OXFORDSHIRE COUNTY COUNCIL'S RESPONSE TO CONSULTATION ON THE FOLLOWING DEVELOPMENT PROPOSAL

Application no: 22/00959/REM

Proposal: Reserved matters application pursuant to outline planning permission 19/00963/OUT to discharge all remaining reserved matters (appearance, landscaping, layout and scale), the full discharge of conditions 1, 14, 17, 18 and 20 and the partial discharge of conditions 5, 7, 11, 12, 13, 19 and 23. The outline planning application was not subject to an environmental impact assessment.

Location: East Of Last House Adjoining And North Of Berry Hill Road Adderbury

BERRY HILL ROAD, ADDERBURY - DRAFT SITE LAYOUT

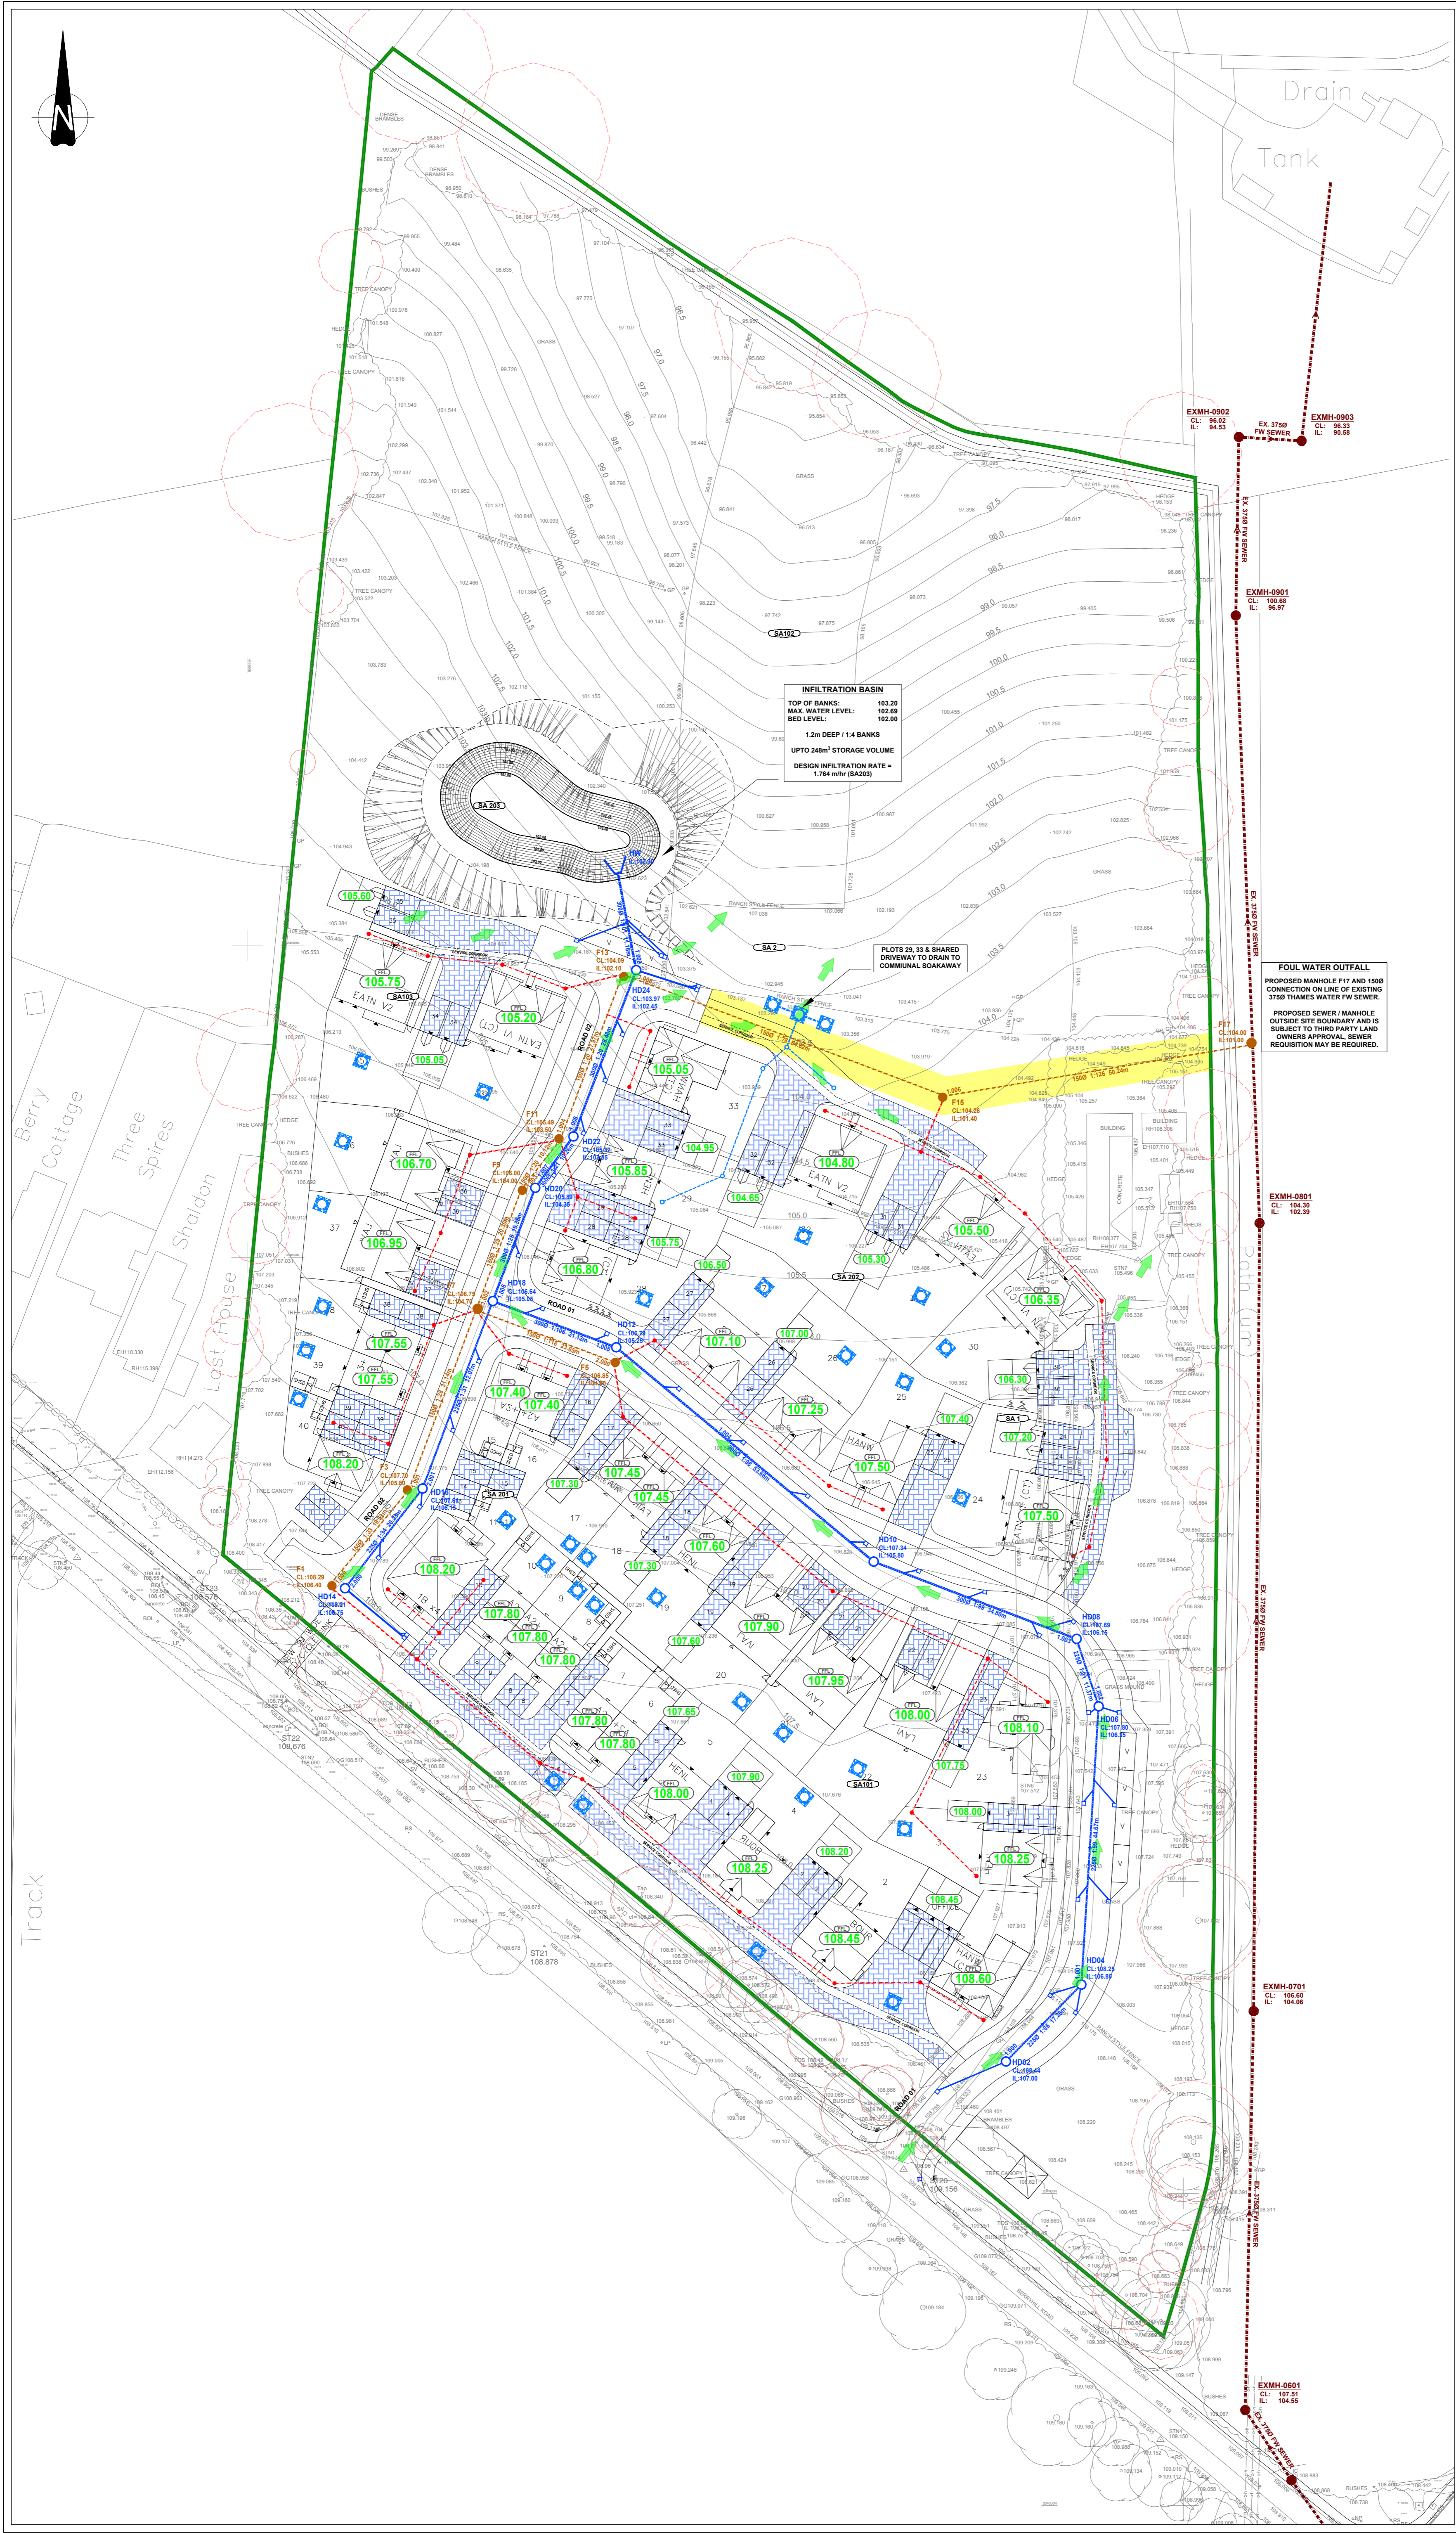
Landing Spots: Where the section of 1:20 longitudinal gradient is present there will need to be flat landing spots.

Swept Path Analysis: Vehicle length does not match the request from OCC Road Agreements.

Where the section of 1:20 longitudinal gradient is present there will need to be flat landing spots. OCC's inclusive mobility guidance states that 'even if there not a pedestrian route in excess of 1:20, it is important that there are level sections or landings at regular intervals to provide people with an opportunity to rest.' A level landing must be provided for every 500mm that a route rises.

- A section 278 application will be required for the access works.
- Where the section of 1:20 longitudinal gradient is present there will need to be flat landing spots.
- Refuse vehicle should be tracked with 11.6m refuse vehicle and should ideally also not overhang the footway as this provides potential for conflict with pedestrians. The vehicle should also be shown tracking past a stationary car to ensure that the refuse vehicle is able to safely manoeuvre around the sections of road that are 4.8m in width.

- The carriageways that are straight for over 70m will require some form of traffic calming to ensure vehicle speeds are less than 20mph.
- Where there is not a footway adjacent to the carriageway a 6-metre-wide shared surface block paved carriageway with a minimum 800mm grass margin on either side is required.

- A long section has not been provided and will be required to ensure compliance with the Equalities Act 2010. This must include details of the vertical alignment to determine appropriate carriageway and footway gradients. They will need to be DDA compliant i.e. maximum 1:21 or 5%.

- There are no visibility splays indicated. Junction and Forward Visibility Splays and dimensions must be in accordance with the OCC Street Design Guide and dedicated to OCC if they fall out of the existing highway boundary.
